**WEST SUSSEX COUNTY COUNCIL
STRATEGIC PLANNING CONSULTATION**

SUBJECT: R/149/12 - Alterations to car park layout, access and landscaping.

**Focus, Unit A, Rustington Retail Park, New Road, Rustington, West Sussex,
BN16 3RT**

RECOMMENDATION:

Temporary Store - Permanent Site Plan
Scale 1 : 500

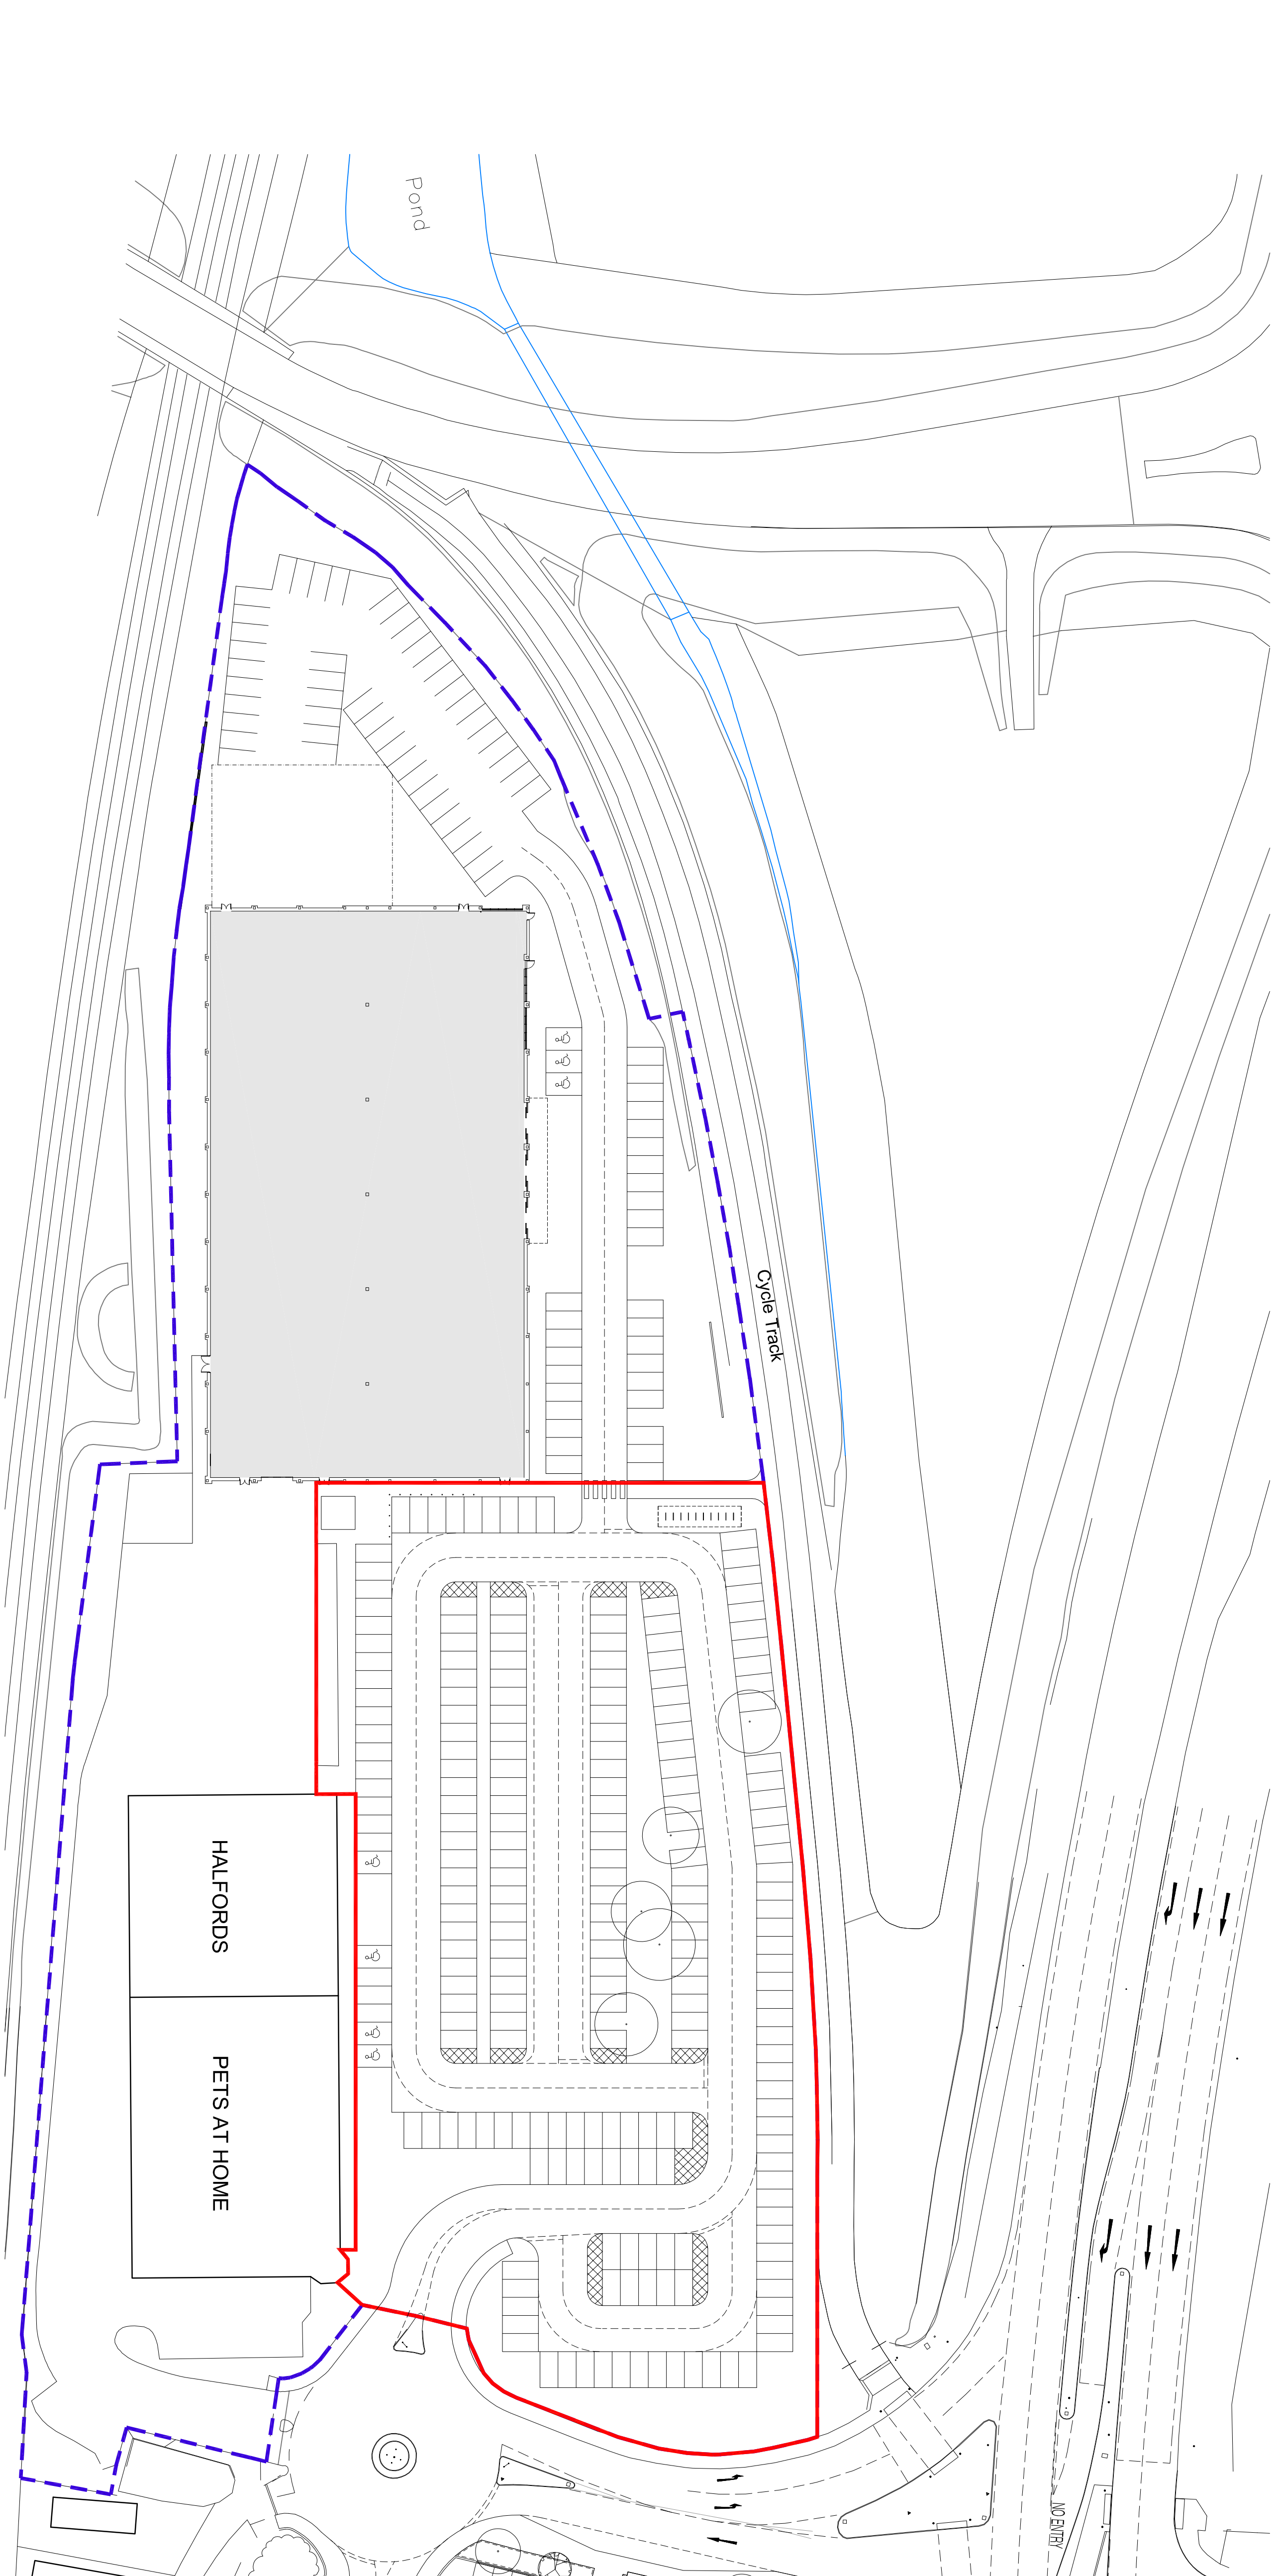
The planning authority is requested to apply a condition to any consent to ensure that the eventual form of the car park once the temporary use of the "Focus" retail unit is ended accords with the submitted plans.

The locations of the proposed footway between the public footway/cycleway on the northern boundary of the retail park to the retail units or the pedestrian guard railing to the east (Technical Note, 1.15) are not defined. Both facilities will be on the public highway and the approval of the highway authority will be needed. This should be subject to conditions:

Before the development is brought into use the proposed pedestrian access to the public footway/cycleway on the northern boundary of the retail park shall be designed/constructed in accordance with a scheme to be submitted to and approved in writing by the Local Planning Authority, all to be permanently maintained to a specification to be agreed with the Local Planning Authority.

Before the development is brought into use the proposed pedestrian guard railing on the eastern boundary of the retail park shall be designed/constructed in accordance with a scheme to be submitted to and approved in writing by the Local Planning Authority, all to be permanently maintained to a specification to be agreed with the Local Planning Authority.

No new development shall be occupied until space has been laid out within the site in accordance with the approved plans for maximum 305 cars/minimum 20 cycles to be parked and for vehicles to turn so that they may enter and leave the site in forward gear. The parking/turning area shall be used and retained exclusively for its designated purpose.
